June 6, 2016

Re: Holly Subdivision – Grading and Drainage Plan for Grading Permit

We are requesting a review of the attached information in support of the Grading Permit of Holly Subdivision and the construction of Holly Ave. The comments of 5/4/2016 have been addressed with the following:

CITY OF ALBUQUERQUE
 PUBLIC WORKS DEPARTMENT
 ENGINEERING DEVELOPMENT GROUP
HOLLY SUBDIVISION
 GRADING AND DRAINAGE PLAN

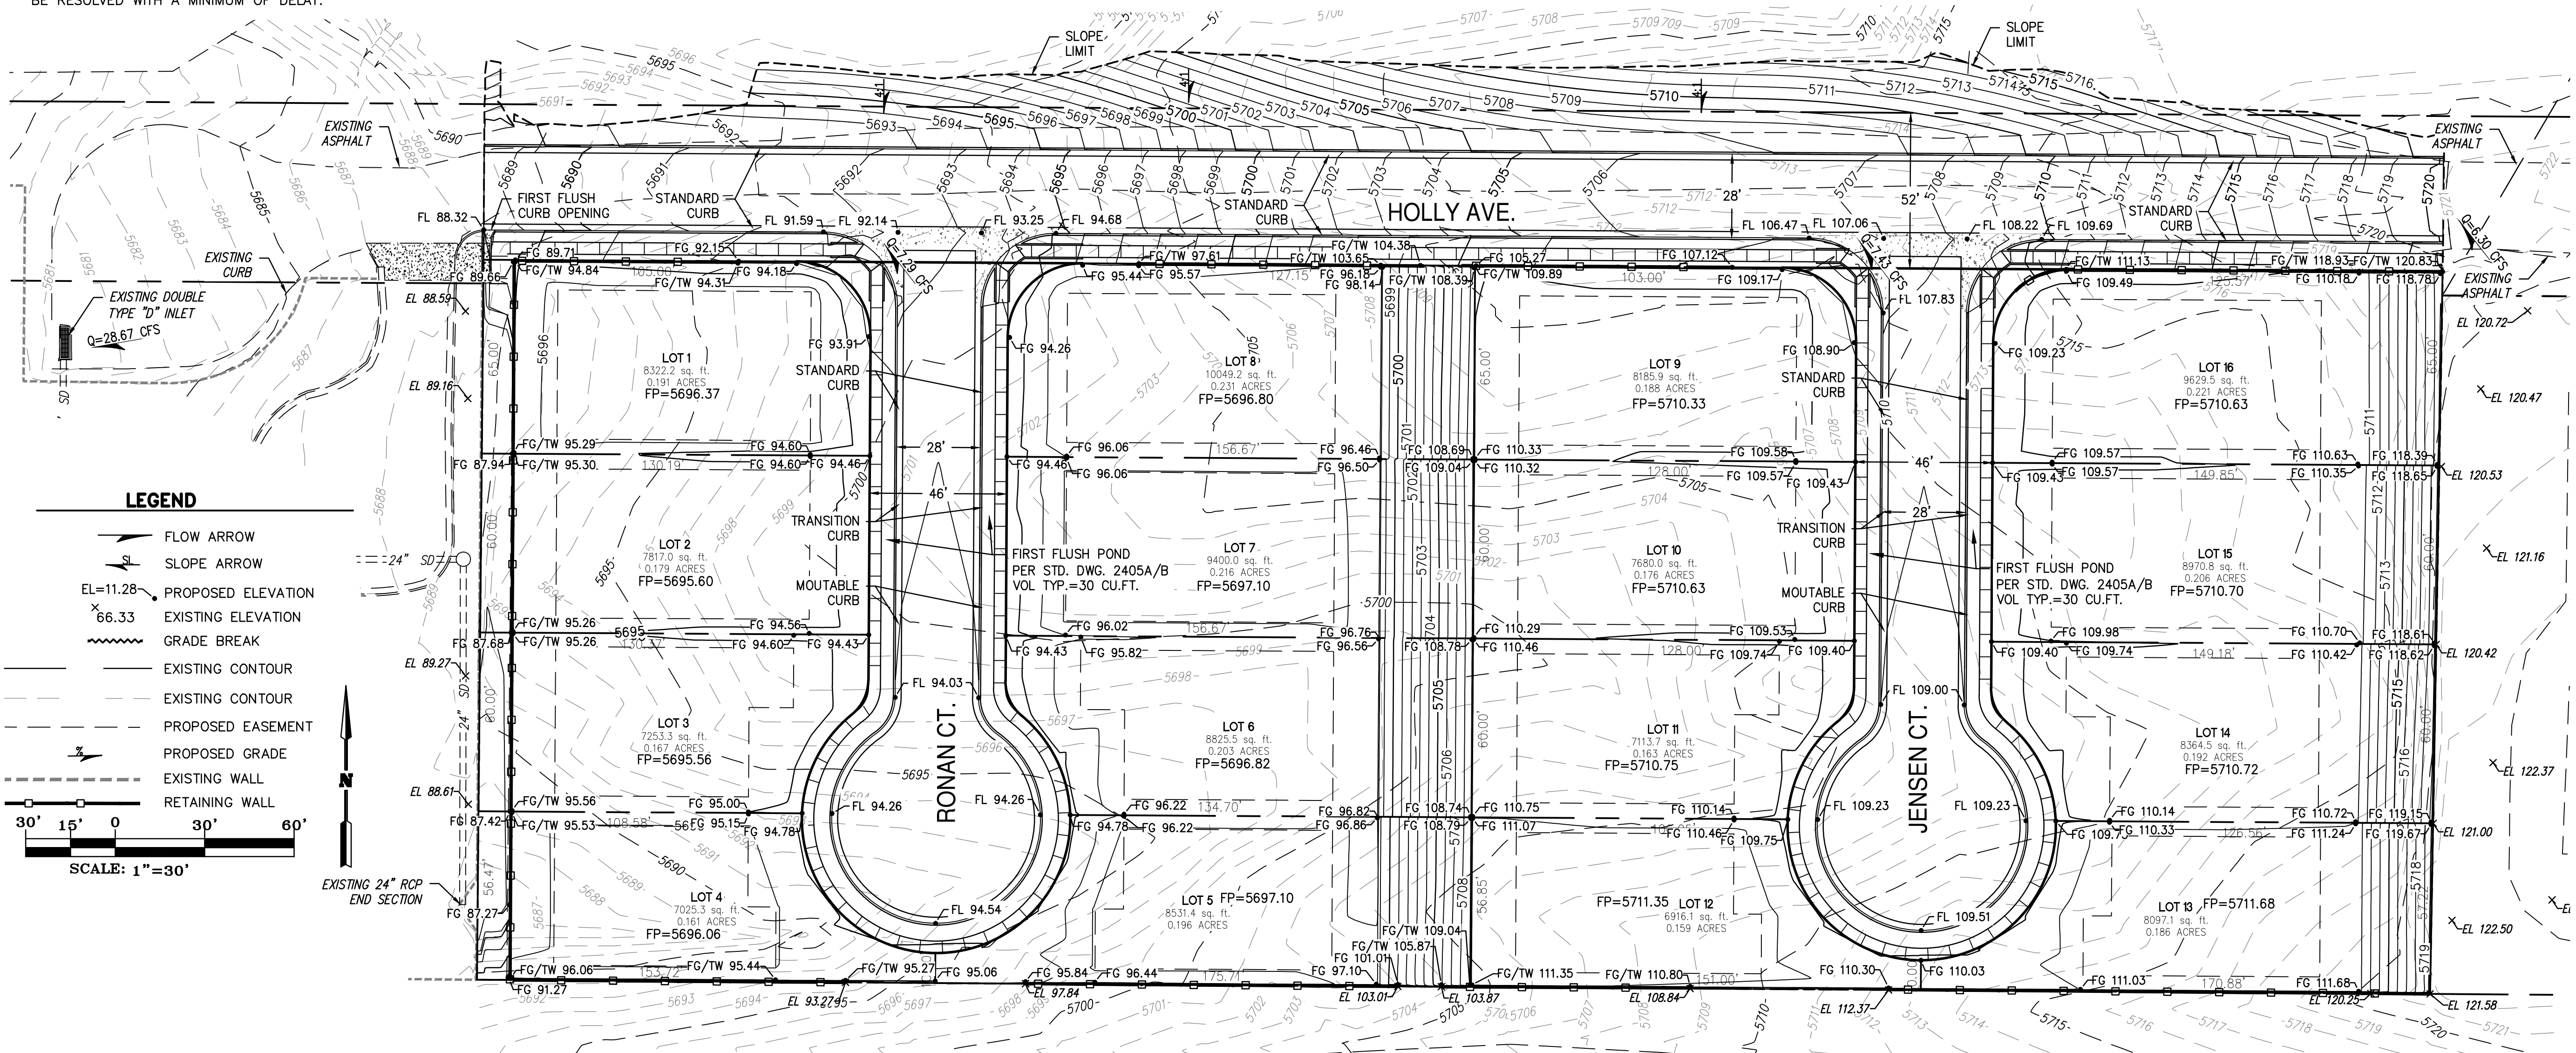
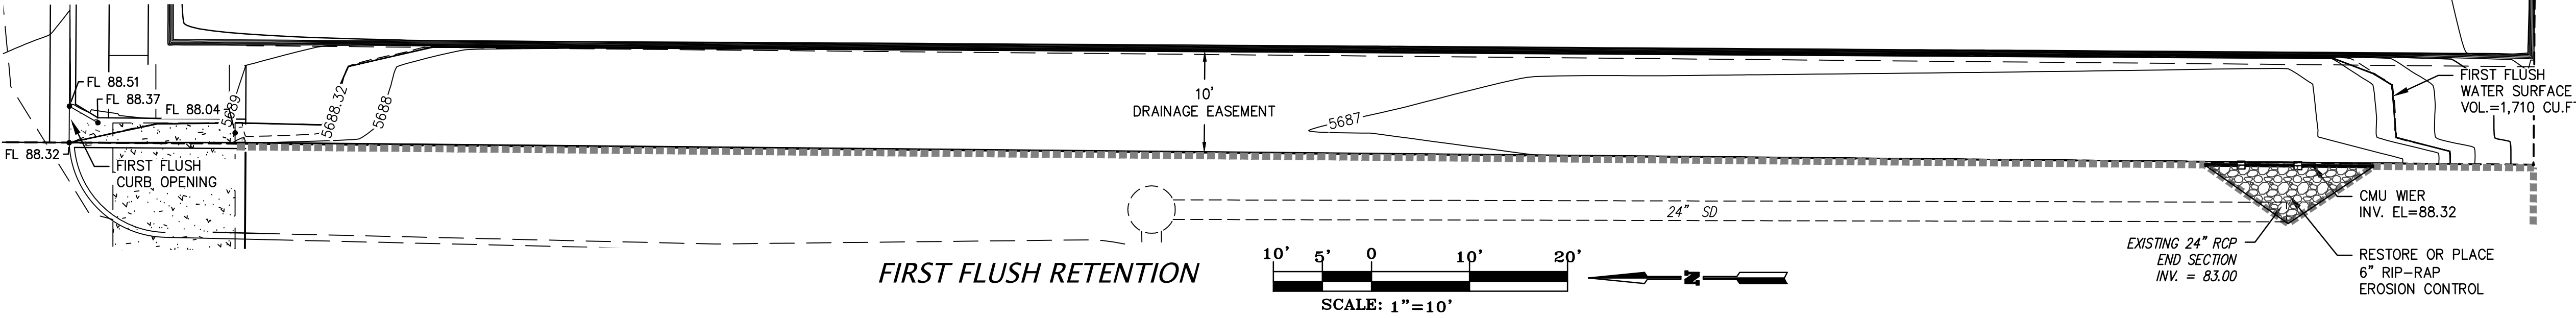
- We understand that Parks and Rec and Transportation Development have removed the requirement for a North-South pedestrian path along the west edge of the site; the final plan is expected to have that facility removed.*
The pedestrian access has been removed.

- We understand that there is an arrangement regarding the necessary grading into the adjacent site to the north to construct Holly Ave. Please forward the communication with AMAFCA which is anticipated to show that there is permission to grade within their property and the maintenance responsibilities.*
The communications are attached.

- Provide a hydraulic capacity calculation for the mountable curbed streets.*
The curb has been modified to standard curb where necessary to increase capacity.

- Provide erosion control (or clean the area if some erosion control exists under sediment) at the entrance to the 24" end section. Since the elevation of the CMU wall opening is set exactly at the same elevation as the opening in the curb, minor field discrepancies in the wall opening elevation can permanently route much of the flow through the first flush pond.*
Erosion control has been addressed on the plan with restoration or placement of rip-rap.

7. *It is assumed that there will be a solid wall between the Church property to the East and this subdivision that will prevent offsite flows, since cross lot drainage easements are not included in the plat. Provide scour protection or grading that prevents erosion at the bottom of the wall.*

Existing grading and drainage improvements along with the vegetation of the adjacent site currently prevent flows from entering the lots and provide adequate erosion control.
